**Application No:** 21/00283/DISC

**Proposal:** Discharge of conditions 19 (public right of way), 22 (management, storage and/or disposal of spoil), 23 (soil management plan), 48 (vehicular traffic access), 49A (Framework Construction Management Plan) & 49B (Site Specific Construction Management Plan) of 14/01932/OUT

**Location:** OS Parcel 7400 Adjoining And South Of, Salt Way, Banbury

## **Transport Development Control**

TITLE:-  
**Construction Management Plan**

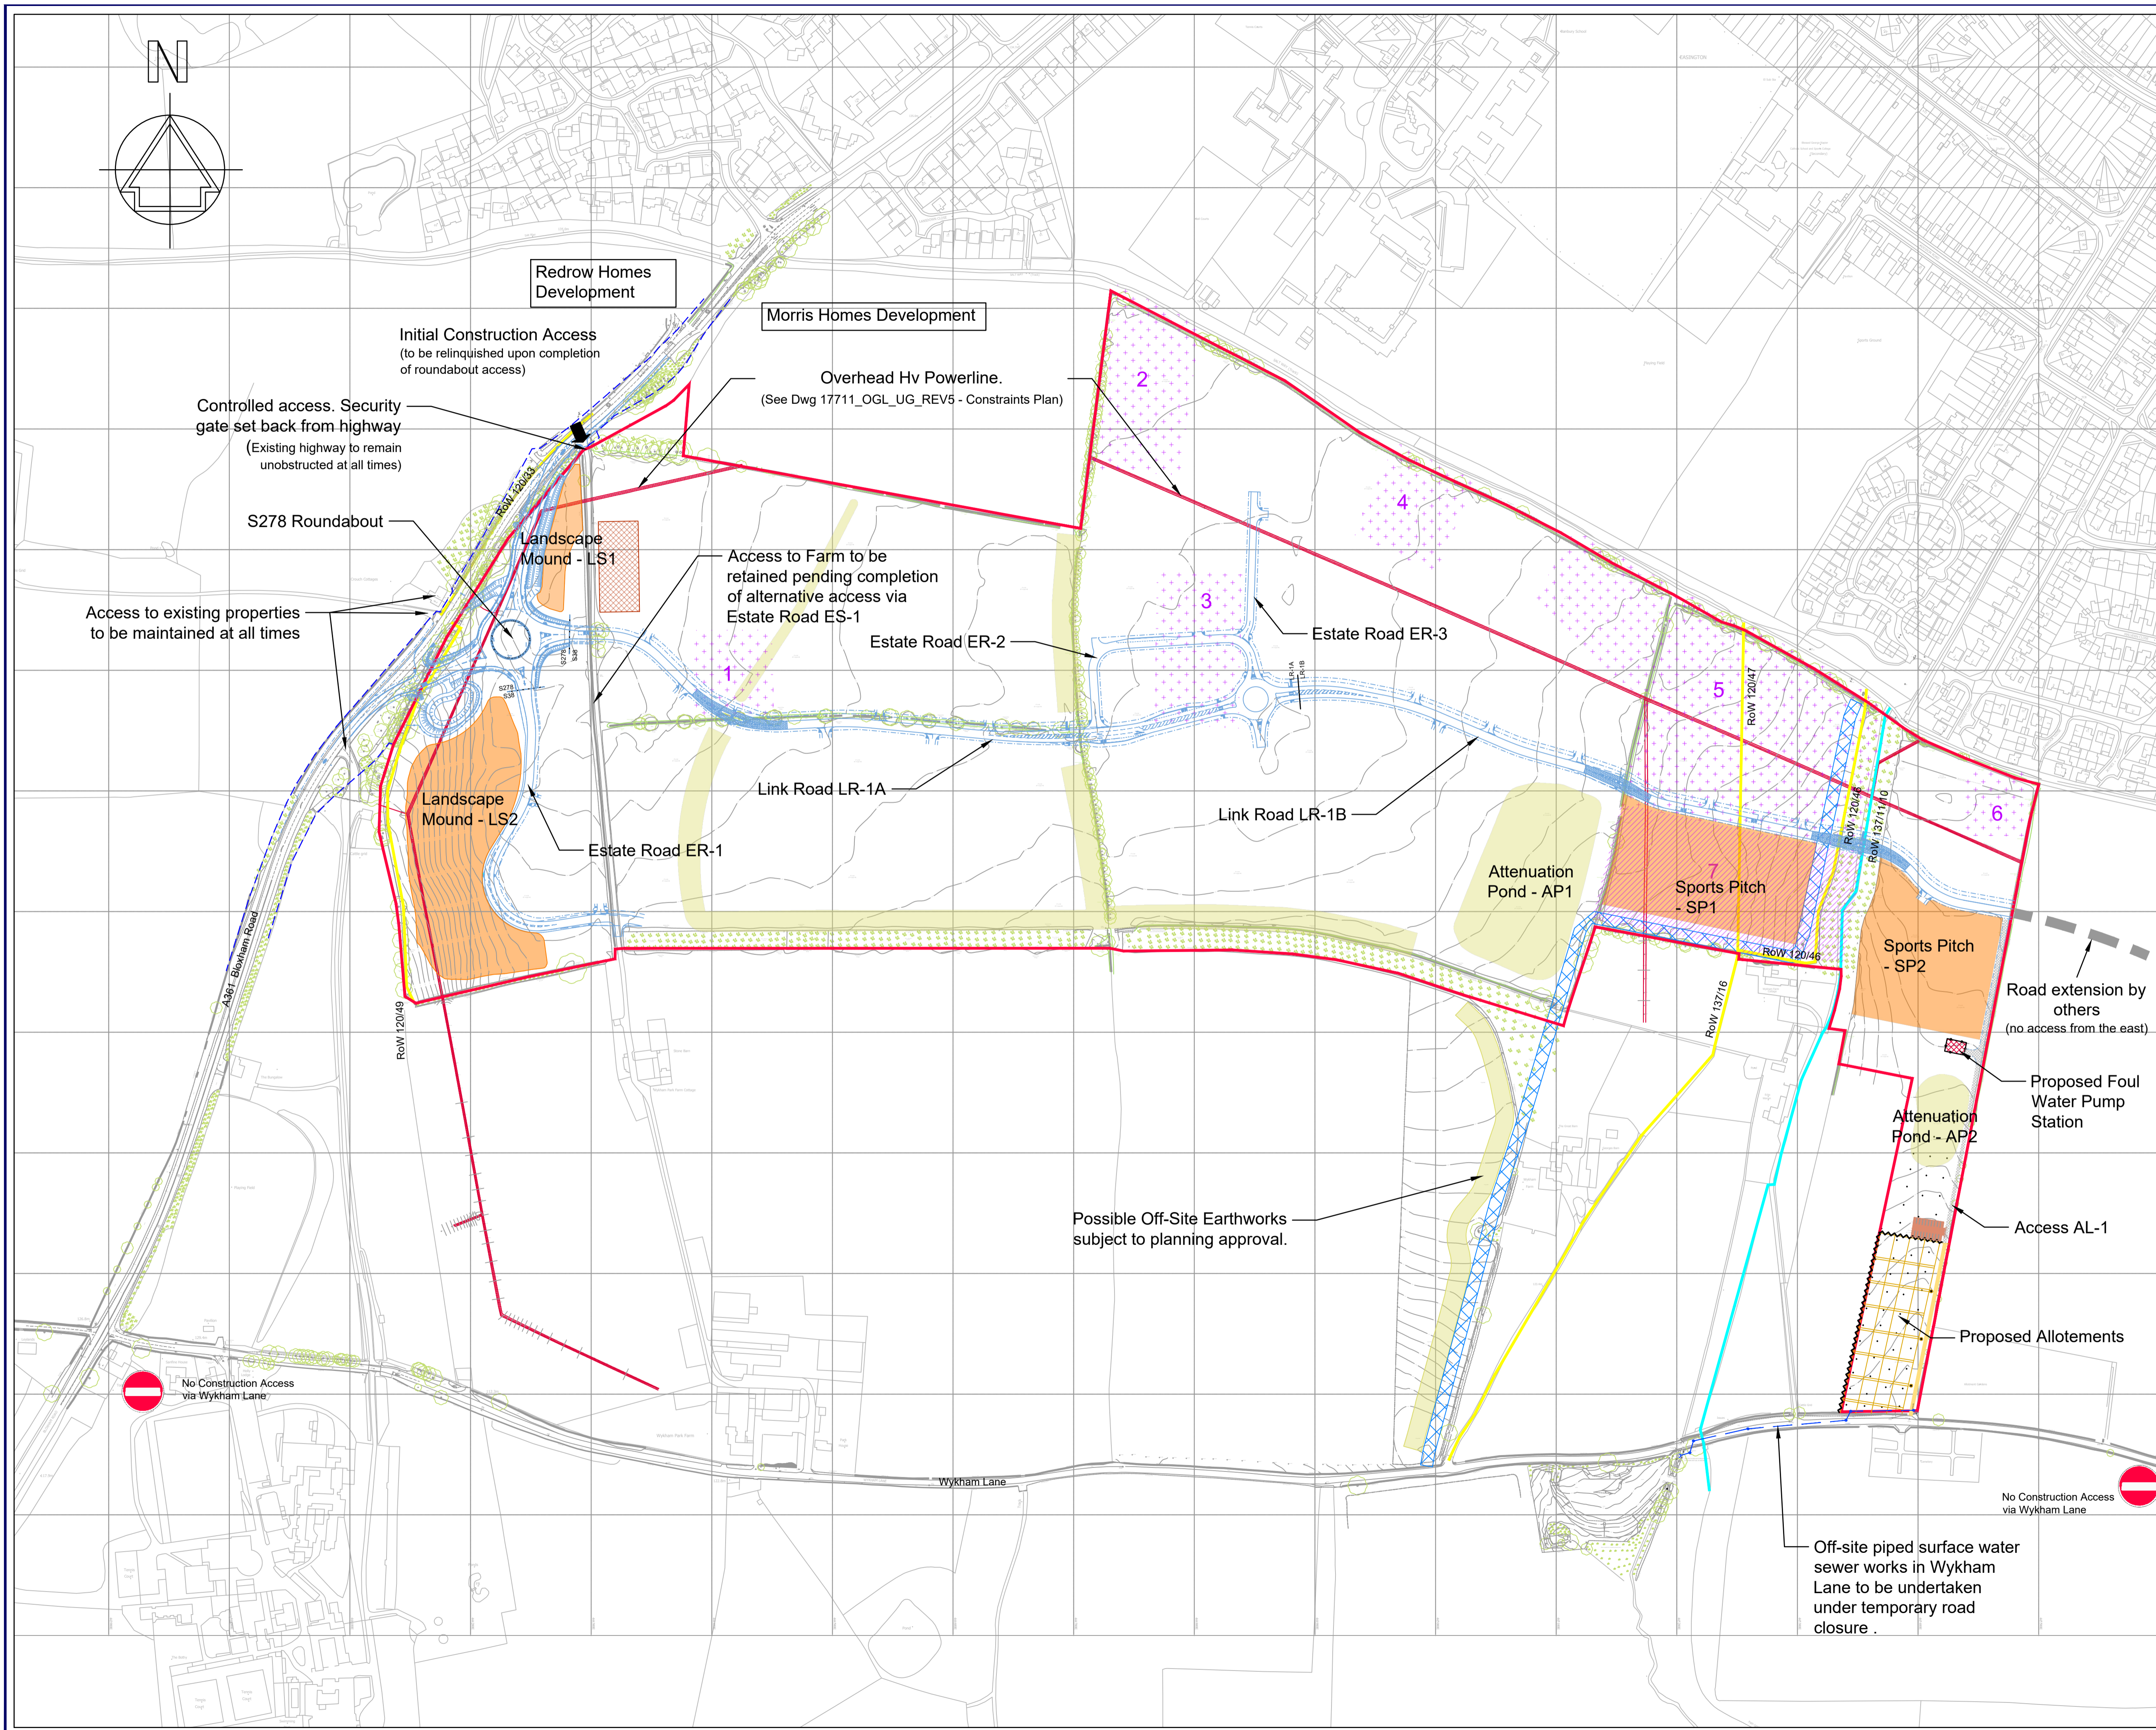
Condition 19: The submission includes insufficient detail of how the rights of way are to be protected to discharge this condition. It is suggested that they are diverted but no details are provided. The LHA objects to the discharge of this condition, based on the information provided.

4.14 This site specific construction management plan needs to show detail of how the rights of way will be diverted and protected.

TITLE  
TEMPORARY CONSTRUCTION ACCESS PLAN

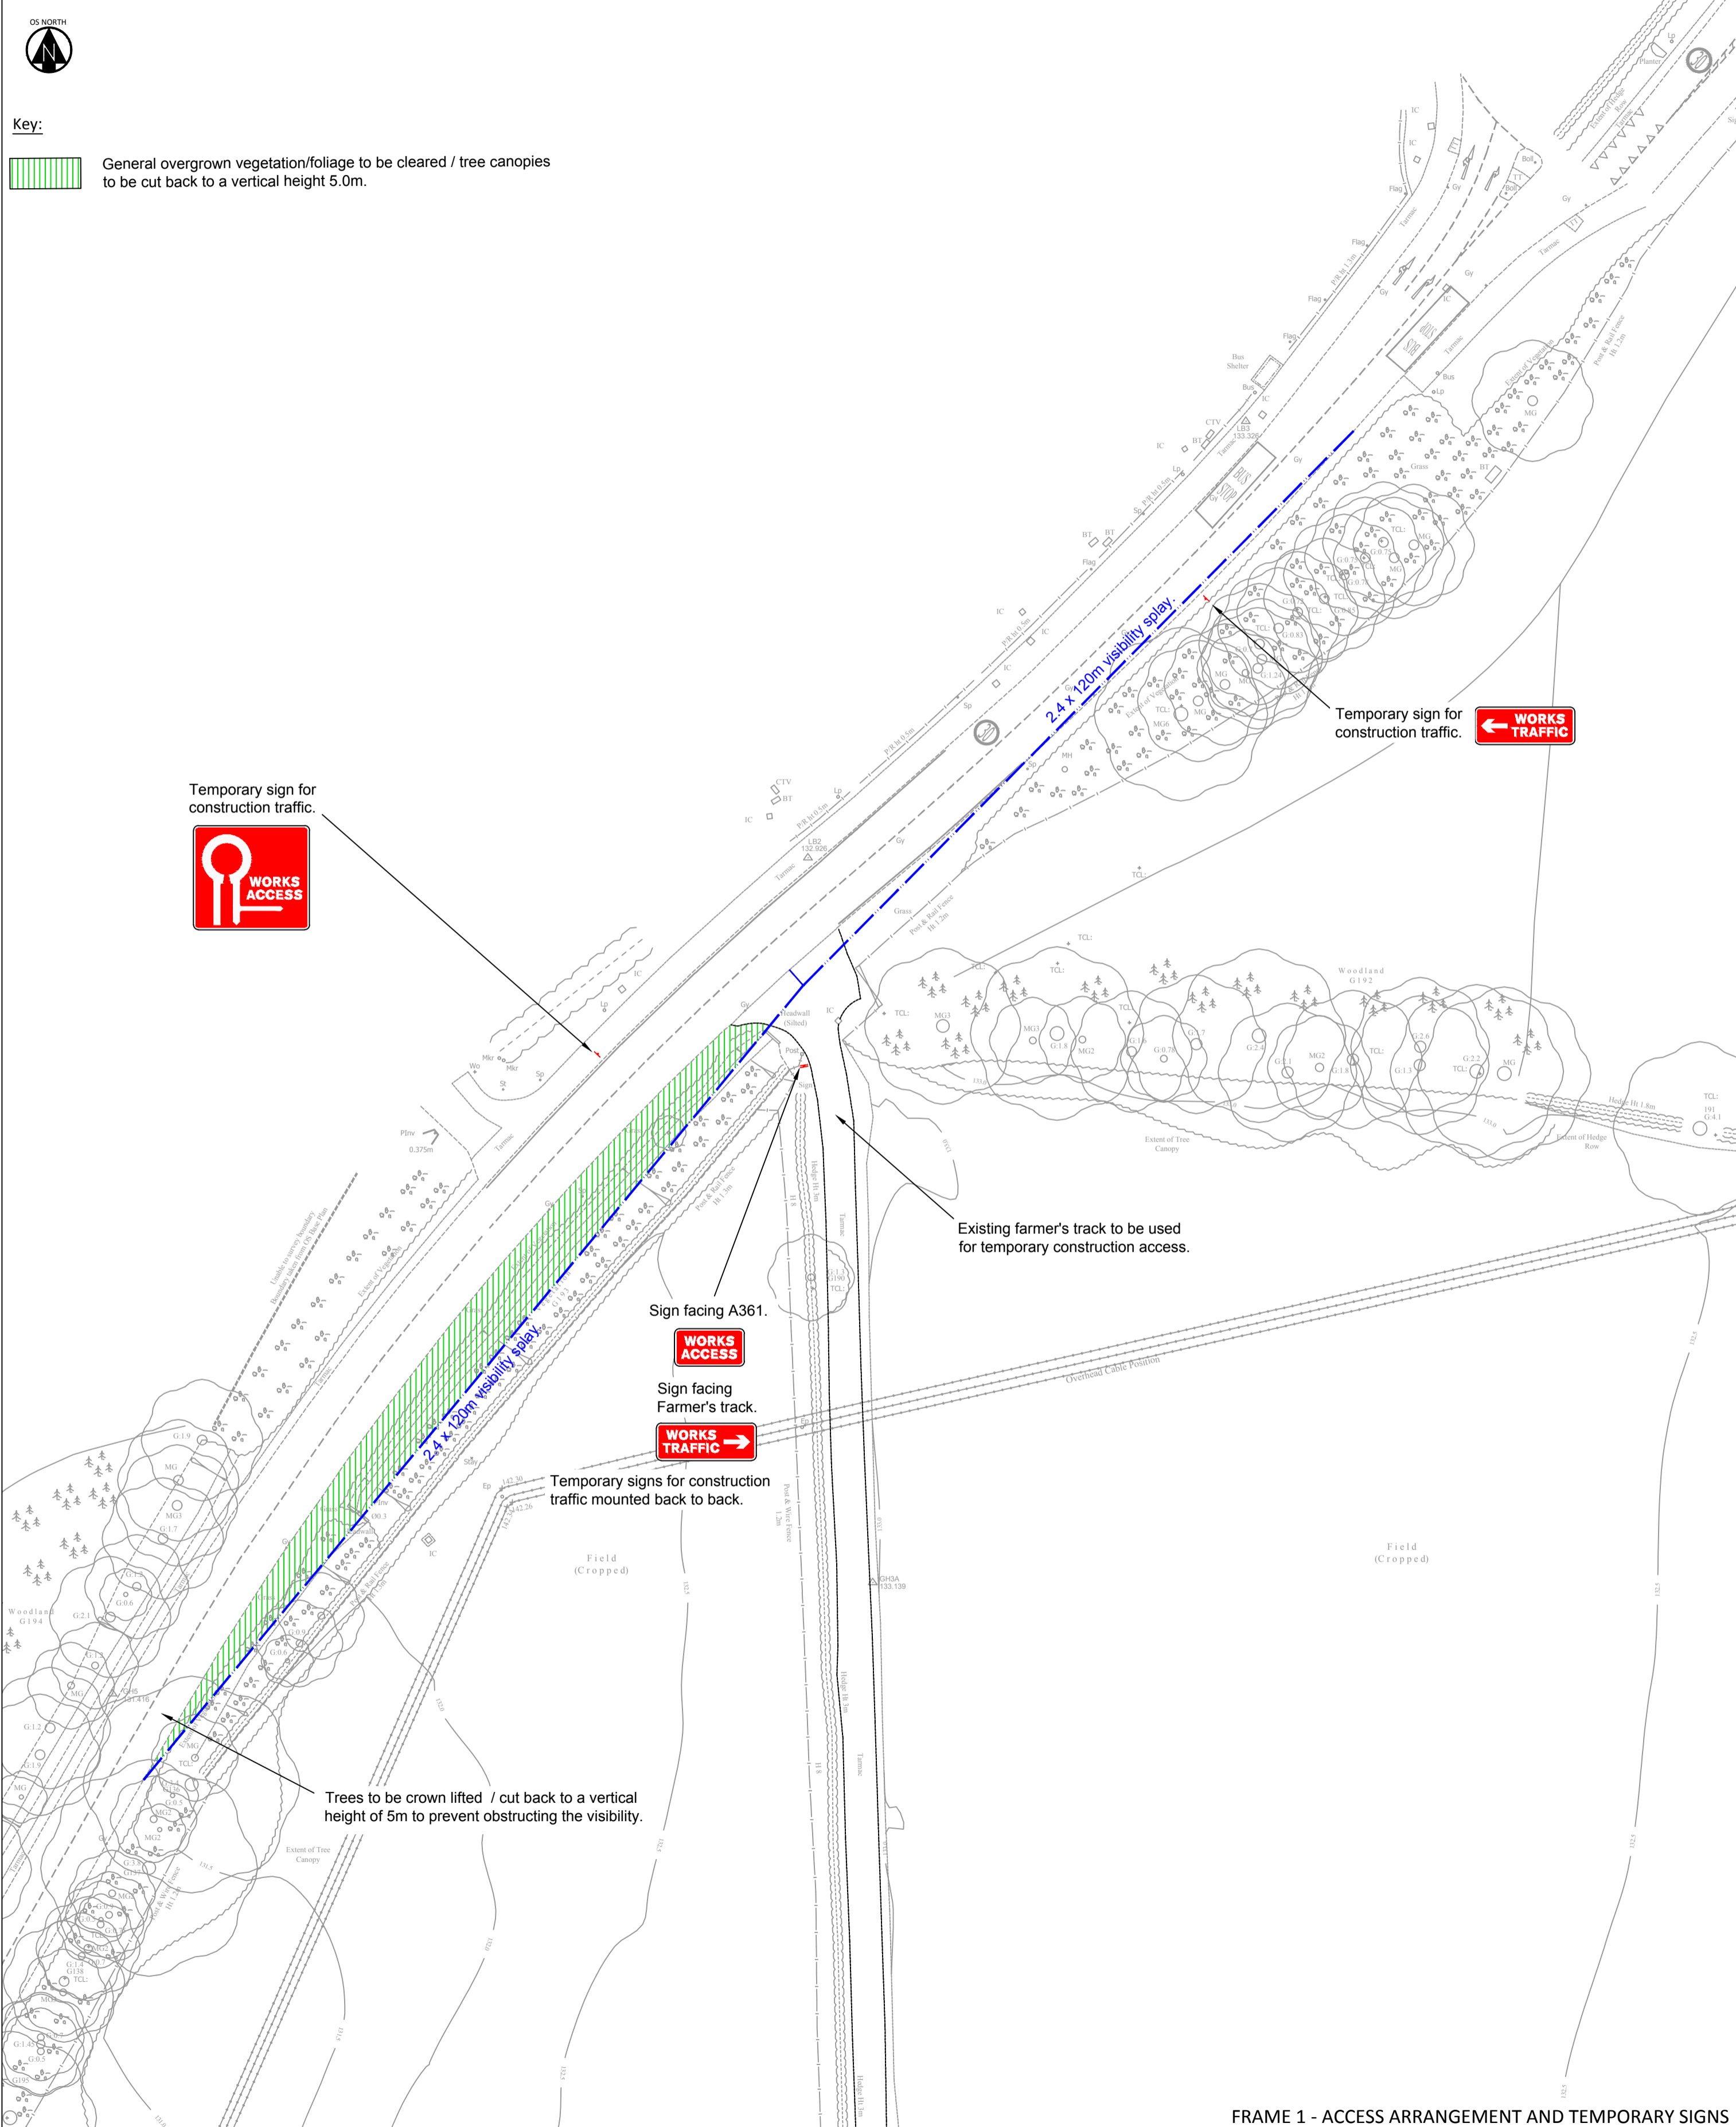
Construction access: A drawing of the construction access should be provided, showing any improvements, gates etc., and visibility splays. The plan should include a requirement to keep vis splays clear. Also, how will access for farm vehicles be maintained while the site is closed and secured?

Construction access: This appears to be within the extent of the S278 works – will an additional construction access be required?
